Re: Cutters Edge
820 Rankin Rd. NE
90-Day Temporary Certificate of Occupancy
Transportation Development Final Inspection
Architect's Stamp dated 05-03-22 (G15-D049)
Certification dated 05-01-23

Based upon the information provided in your submittal received 05-11-23, Transportation Development has no objection to a 90-day Temporary Certificate of Occupancy based. This letter serves as a "green tag" from Transportation Development for a 90-day Temporary Certificate of Occupancy to be issued by the Building and Safety Division.

A1.1
TCL

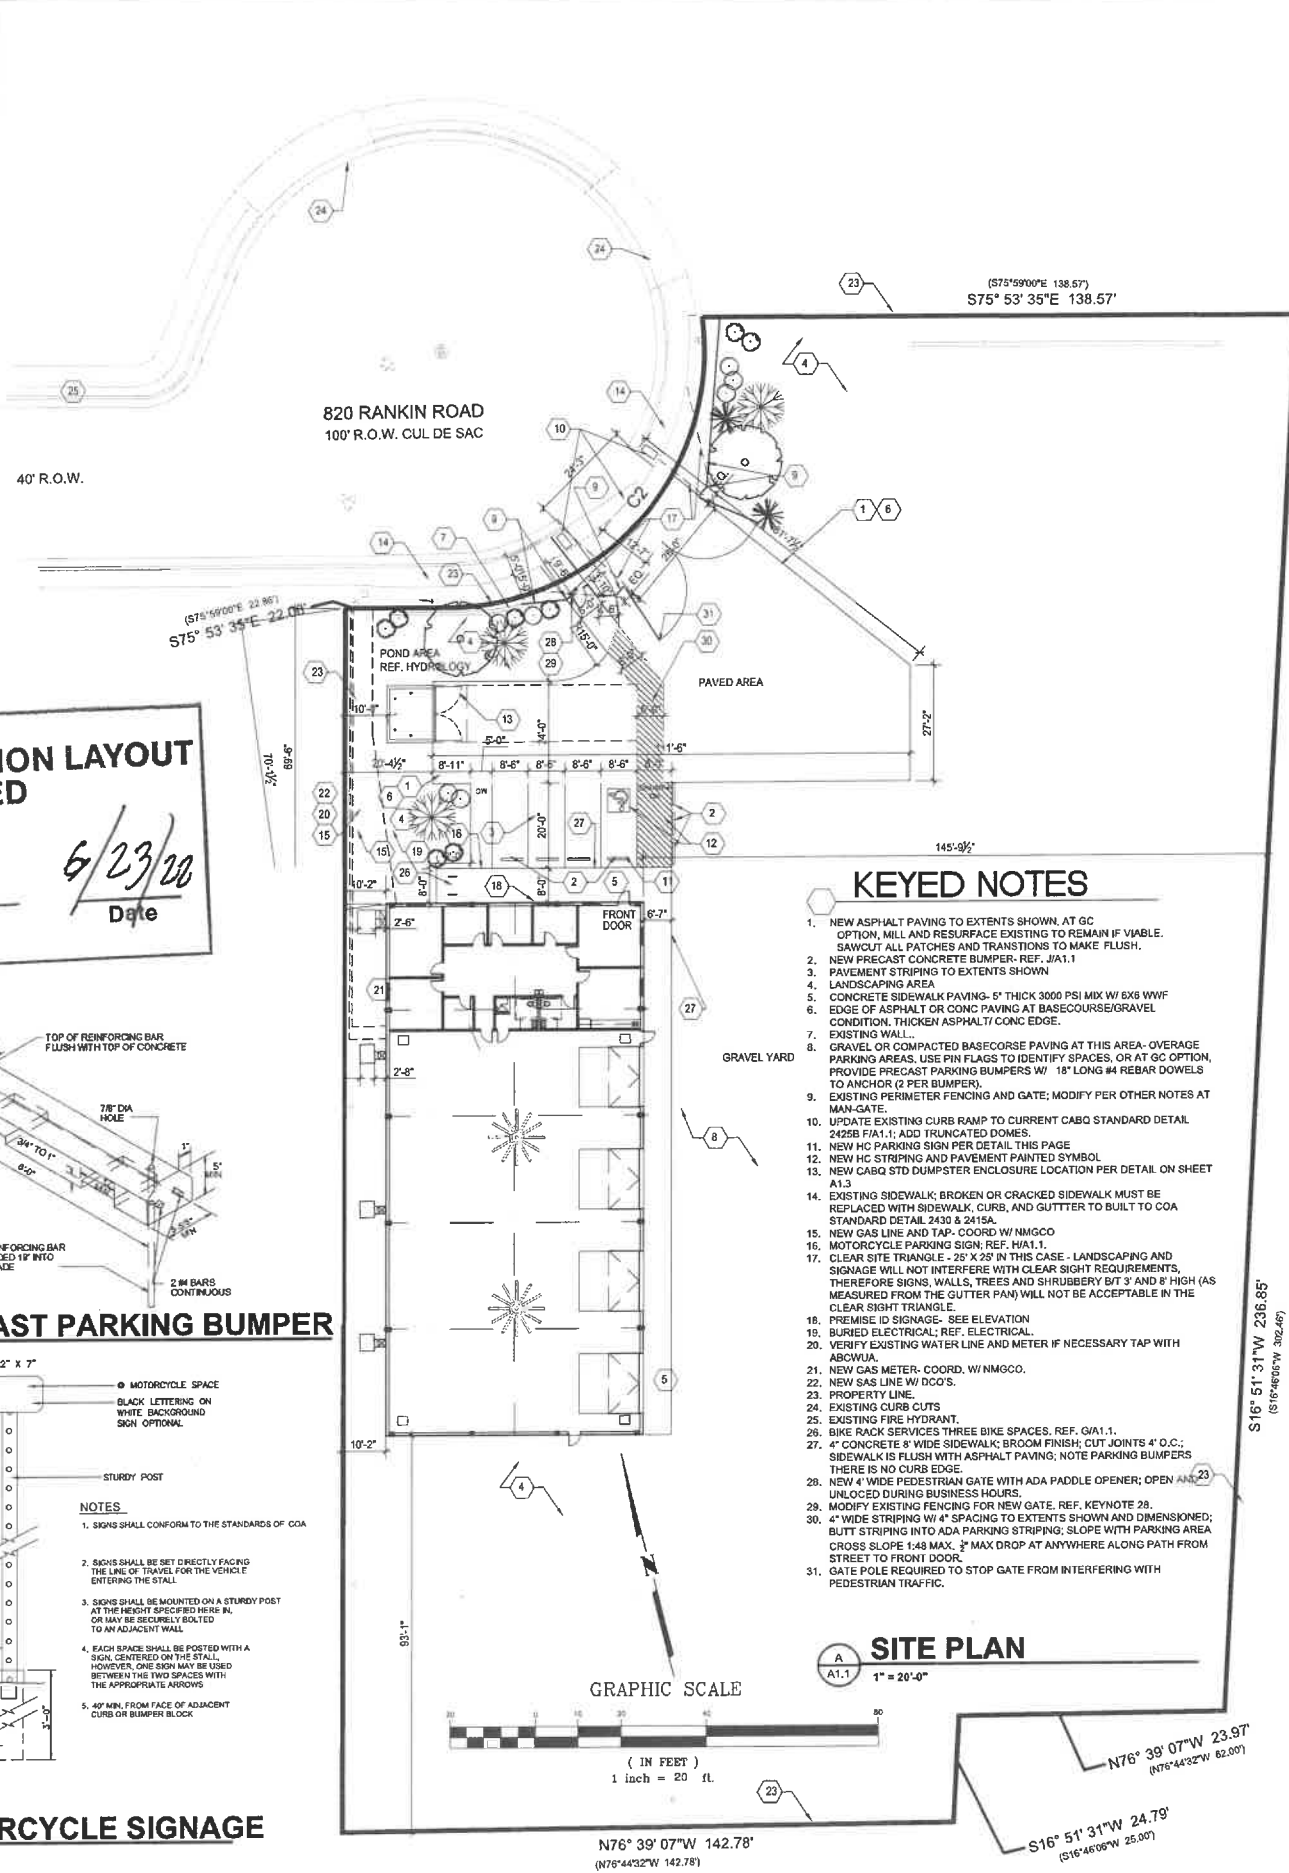
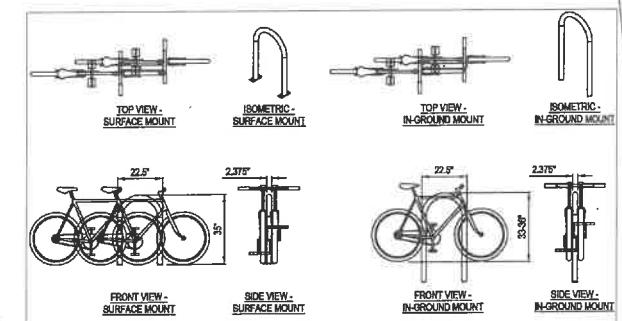
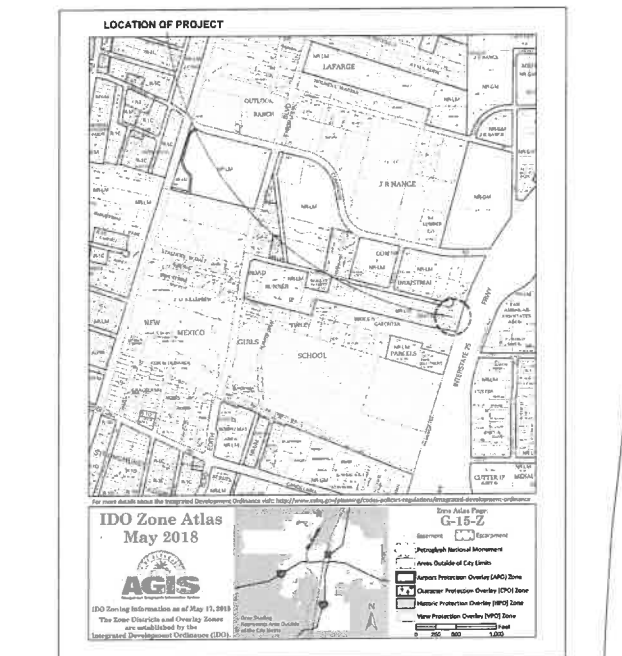
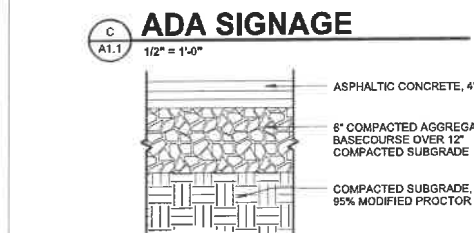
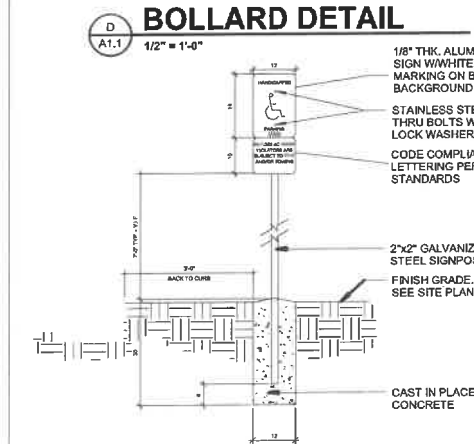
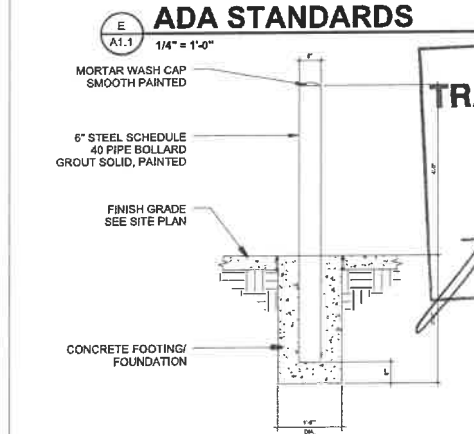
- Driveway access must be built per the approved plan COA std dwg 2425B.
- Anchor down Bike Racks.
- Per approved plan, provide pedestrian gate for pedestrian pathway.
